Application Reference: 2026/0367

Site Address: 63 Rosefinch Road, Goldthorpe, Rotherham, S63 9FS

Introduction: This application seeks planning permission for a Single storey rear extension to dwelling

SHEET NAME Proposed Plans		
DRAWN BY NO	CHECKED BY LO	DATE 11/05/26
SCALE (if A3) As Indicated	PROJECT NUMBER 2379	REV
DRAWING NUMBER P101

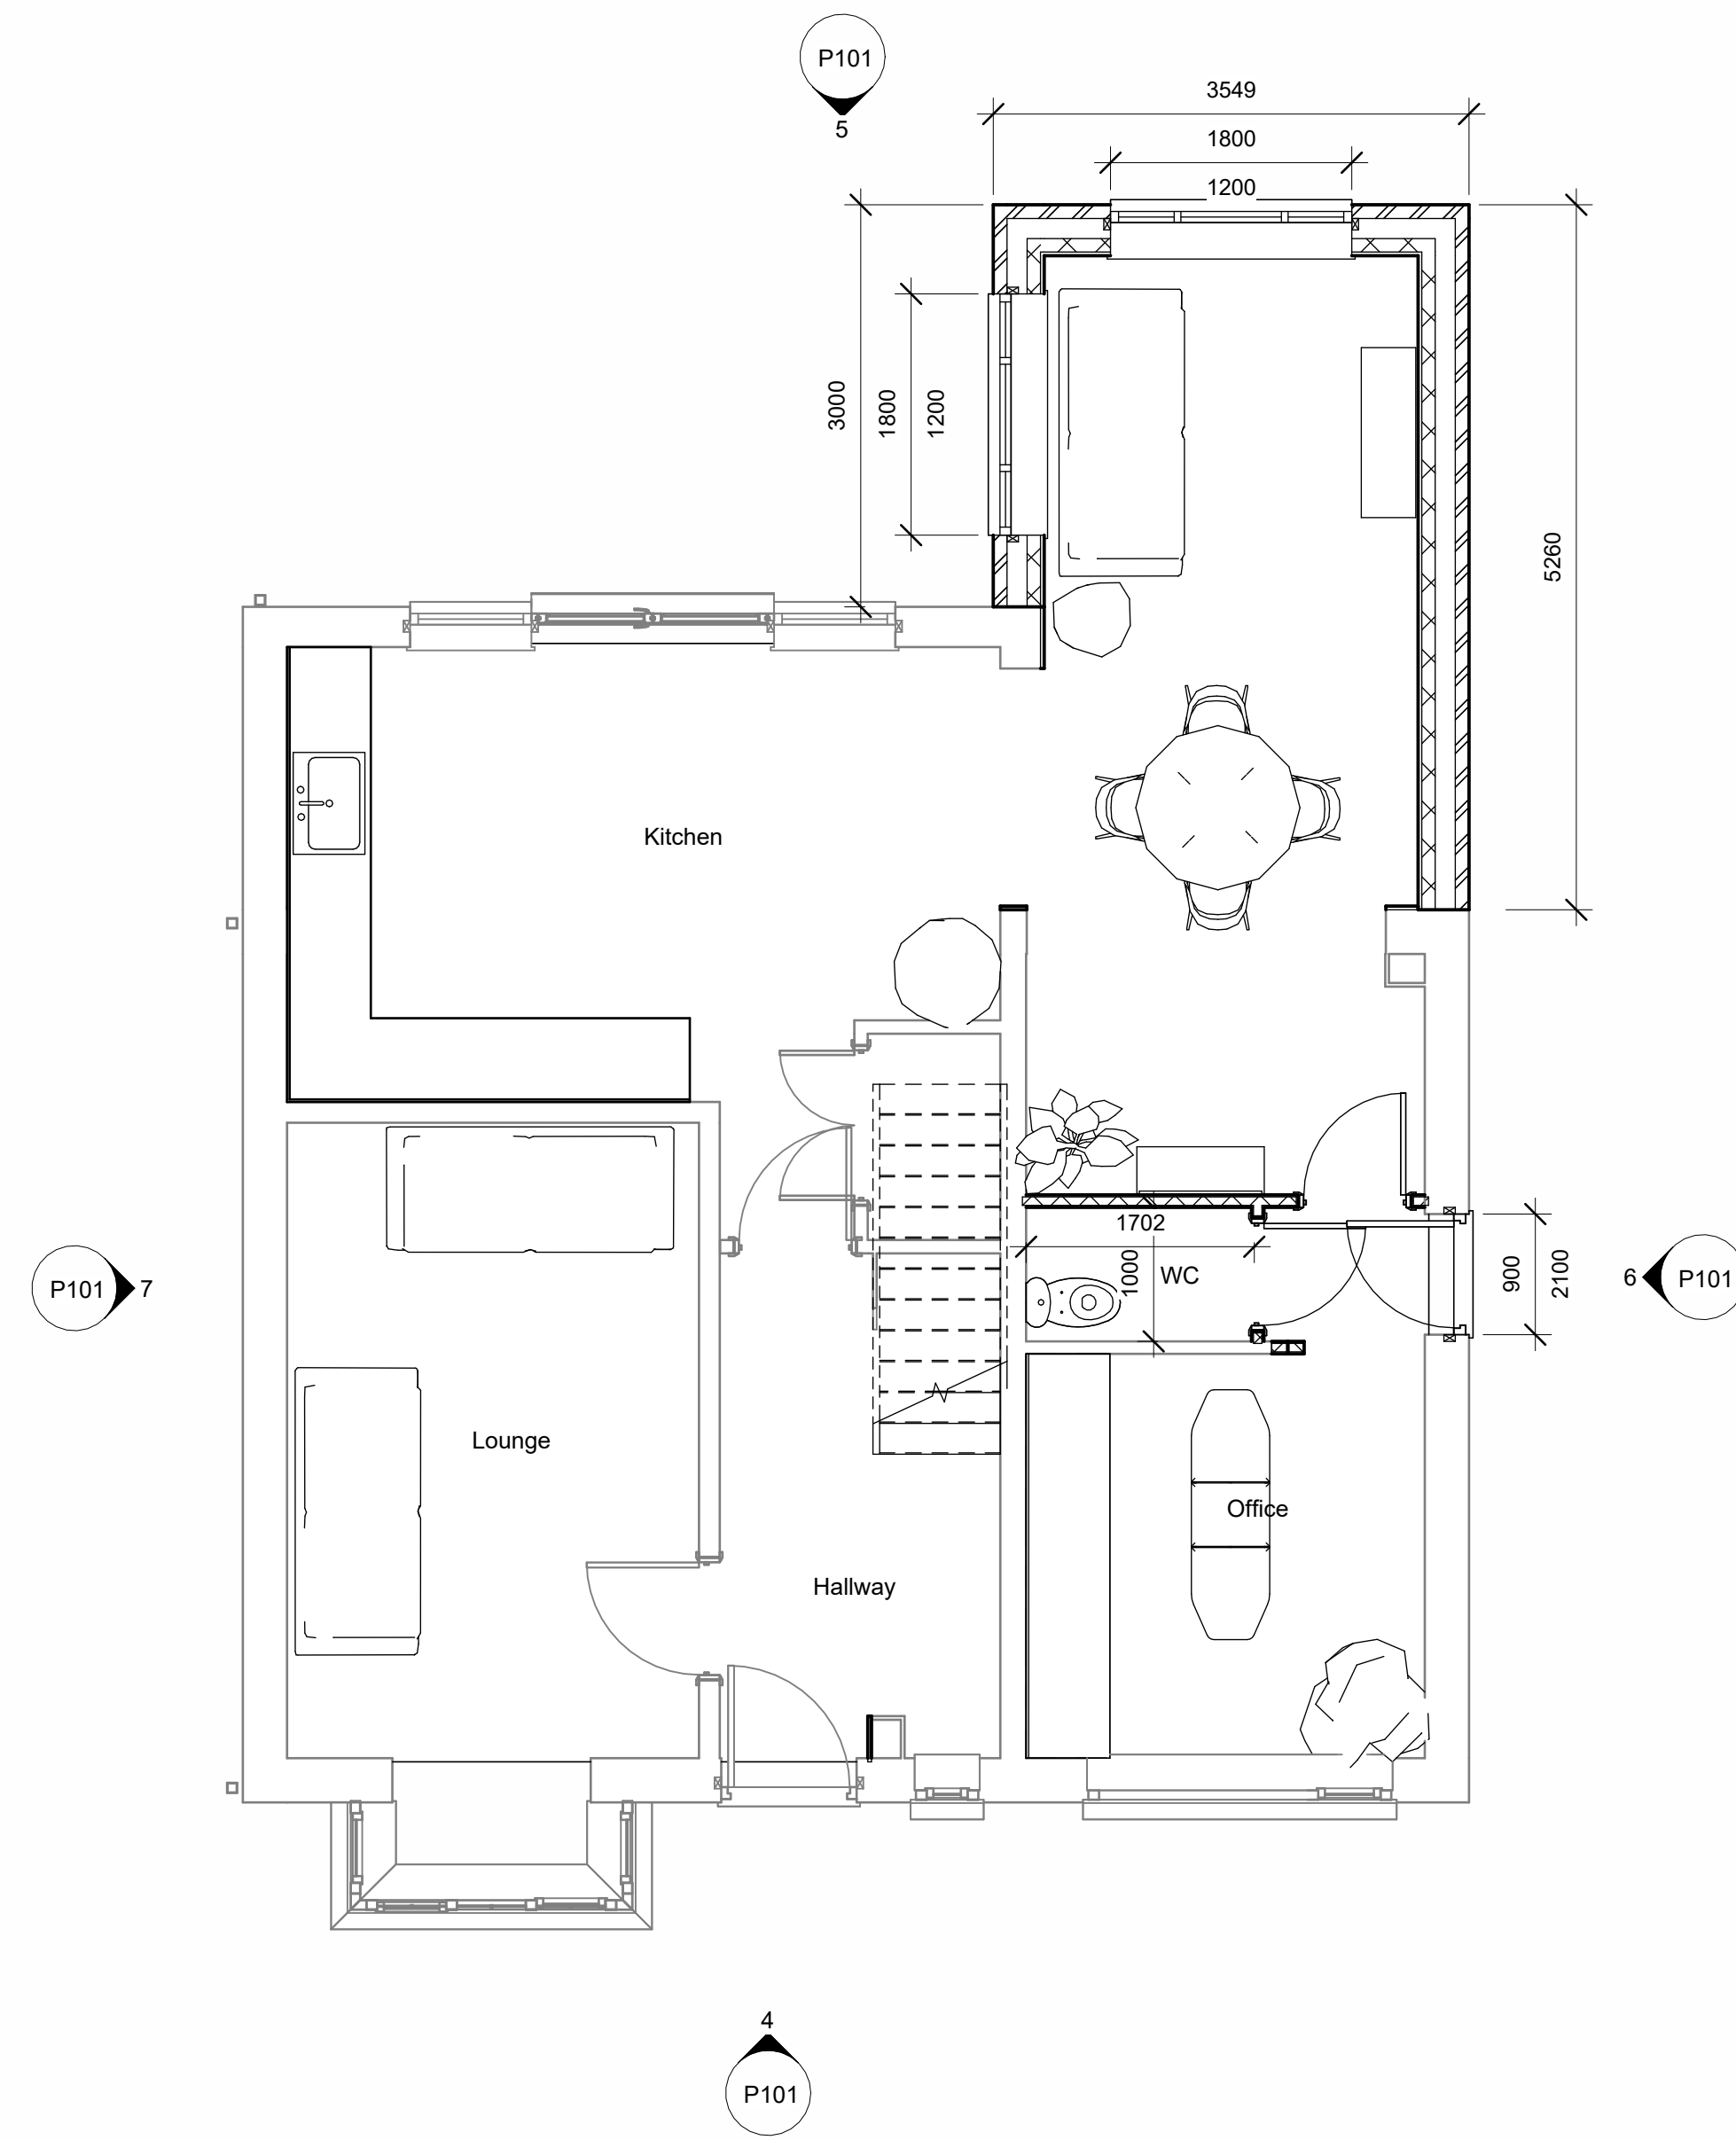
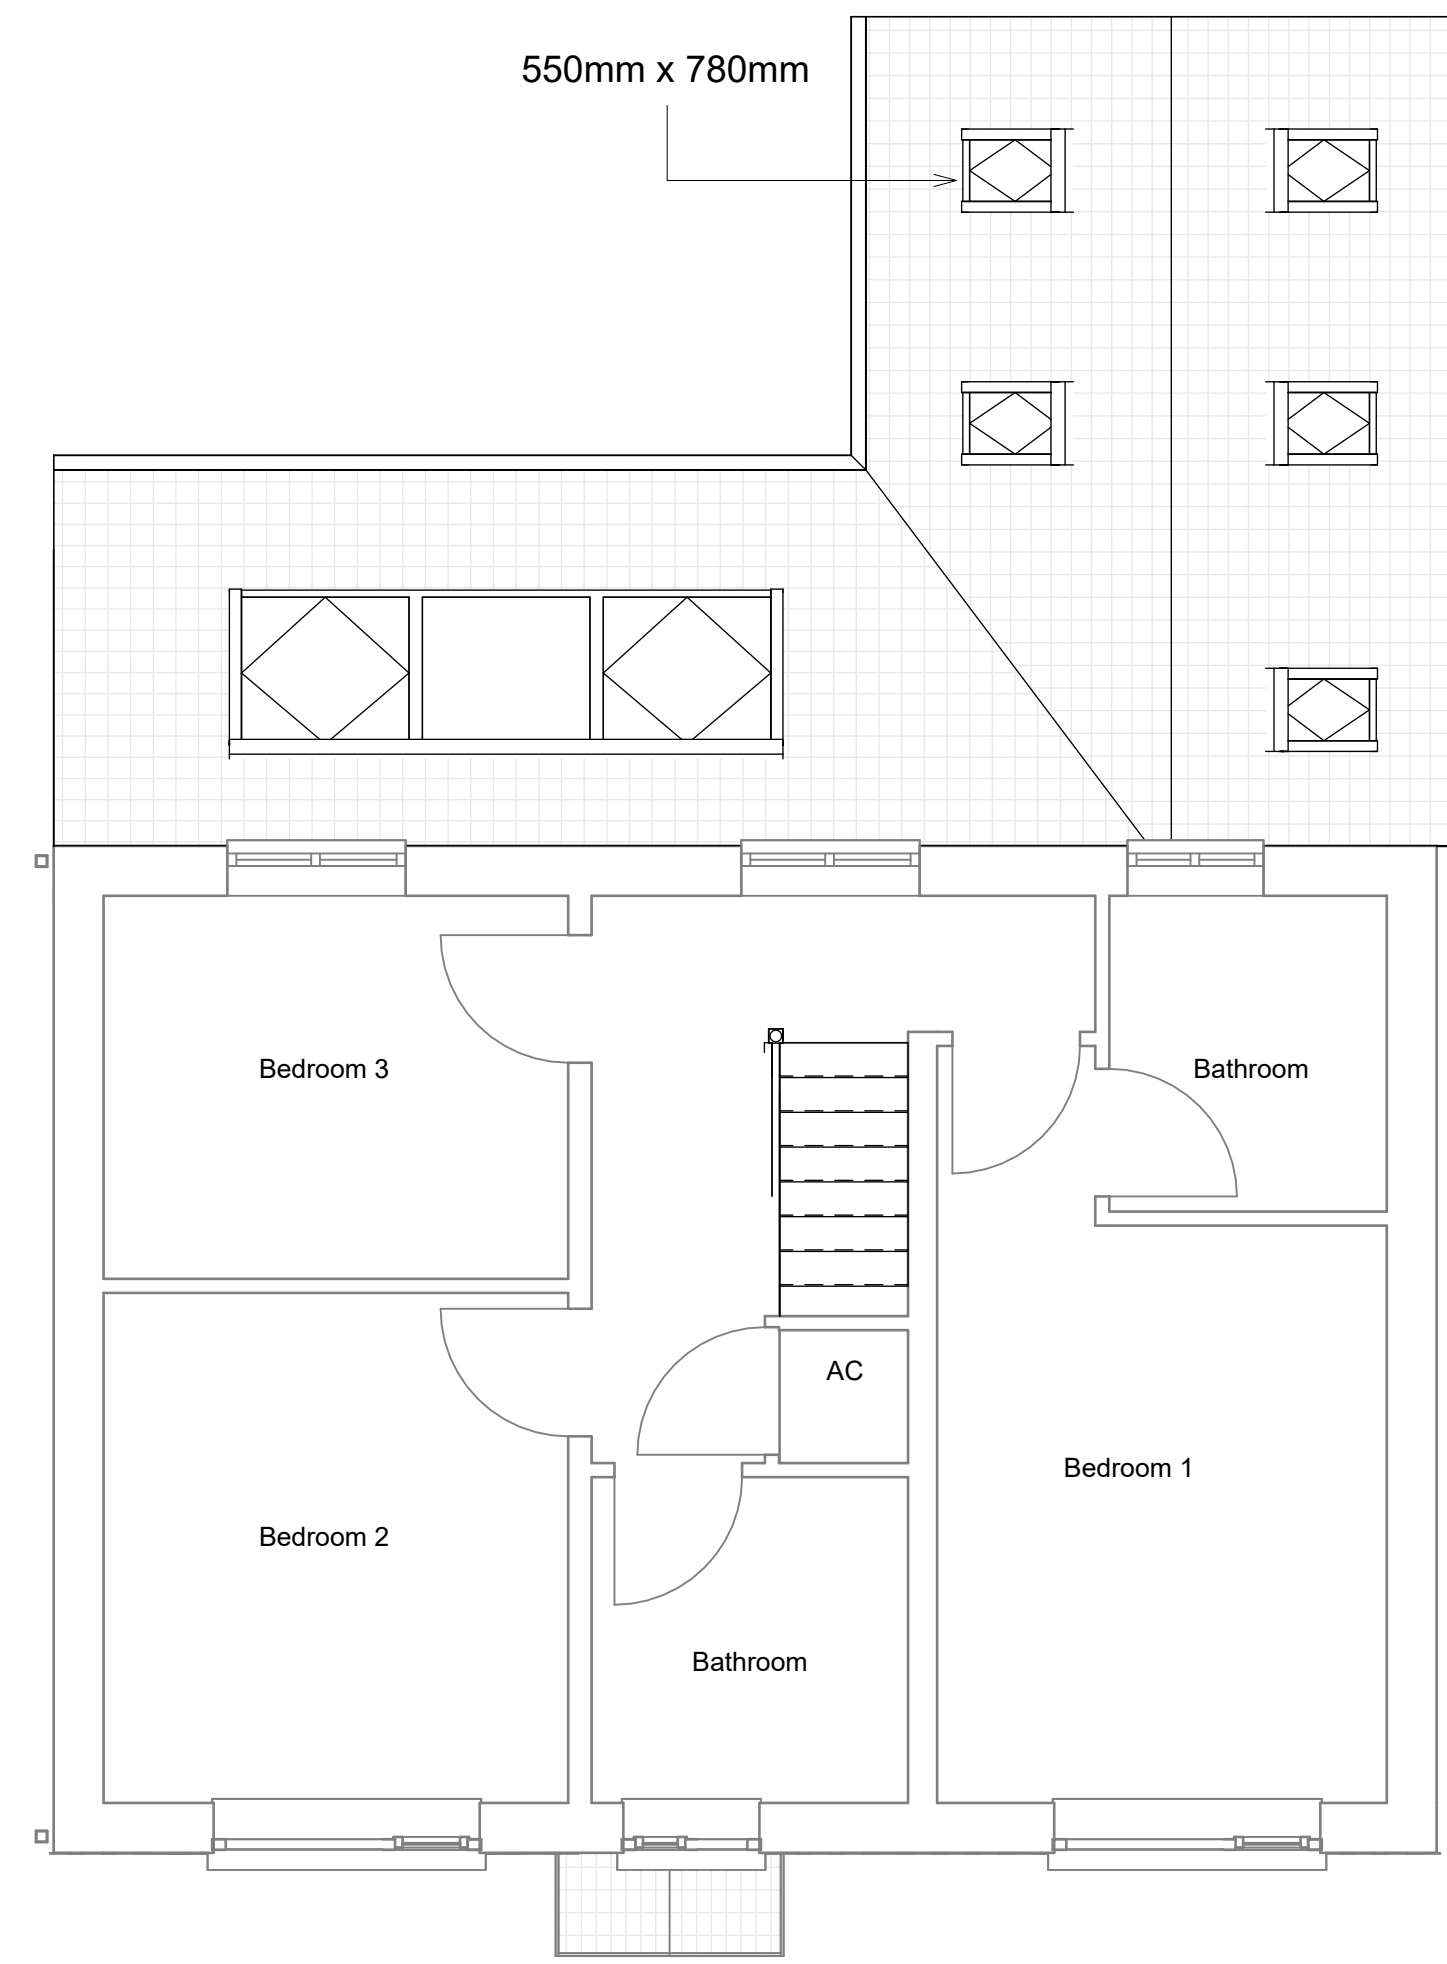
The proposal is a ground floor rear extension, attaching to the existing extension style aspect of the original dwelling. The rear projection would be approximately 5.26m, although only 3m beyond the existing ground floor “extension”.

The scale of the proposal is relatively modest despite in effect being an approximate 5.26m extension, given the existing single storey rear projection of the existing dwelling. In terms of footprint, the proposed extension would only be approximately 18 sqm in comparison to the approximate 77 sqm existing ground floor footprint, representing around a 23% increase.

In terms of height, the proposal features an acceptable eaves height of approximately 2.58m, matching the original rear protrusion's eaves height, and a maximum roof height of around 3.9m. The roof height is slightly higher than the original protrusion, with its approximate maximum height of 3.83m. Both maximum heights are taken on the northern elevation, adjacent to the allotment gardens. Whilst the eaves height remains constant, the roof height of the original protrusion and proposed extension are 3.57m and 3.67m respectively from the adjacent ground level on the southern elevation., but the land level does then drop slightly.

Regarding design, the proposal would use materials of a similar appearance to those used within the existing dwelling, which includes, brickwork, roofing materials, rooflights and window. A proposed additional entranceway on the original side elevation of the dwelling is proposed, which would be of a standard size, although the installed door itself maybe different to the black door installed on the front elevation. The previously proposed door from the 2023 LDC application does not appear to have been installed, and although now proposed further along the side elevation of the original dwelling, would remain as previously, something which could be completed through permitted development.

The dwelling has multiple neighbours to the rear of their garden and an adjacent neighbour on the south of their dwelling, but no residential neighbours in the adjacent allotment gardens to the north. With the extension being ground floor only, maintaining a 7m distance to the rear boundary, and being enclosed by a reasonably high fence, there would be little or no impact for neighbours to the rear.

There is less than a 1m gap between the application dwelling and the boundary treatment with the neighbouring dwelling. Whilst the extension is approximately 5.26m in length, as with the application dwelling, the neighbouring dwelling also features a ground floor rear protrusion. The blank brick wall of the neighbour's protrusion forms the initial boundary treatment for the two dwellings, running for approximately 2.26m before the fence starts. With the proposal extending 3m beyond this point, it would be comparable to an extension being completed through permitted development, if this method had been allowed in the desired location.

Whilst it is recognised that there would be a modest amount of harm to the amenity of the neighbouring dwelling, due to the extent of the extension, and it being taller than the boundary treatment, there would be minimal impact on natural light levels, as the sun rises in the east, to the rear of both dwellings gardens, and proceeds southerly, where the proposed extension would only potentially block sunlight for the applicants garden, before setting in the west, at the front elevations of both dwellings. The standard 45-degree test has also been checked, and a straight line from the approximate centre of the neighbouring dwelling's rear glazed unit, closest to the application dwelling, at an angle of 45-degrees, is not intercepted by the applicant's proposed extension.
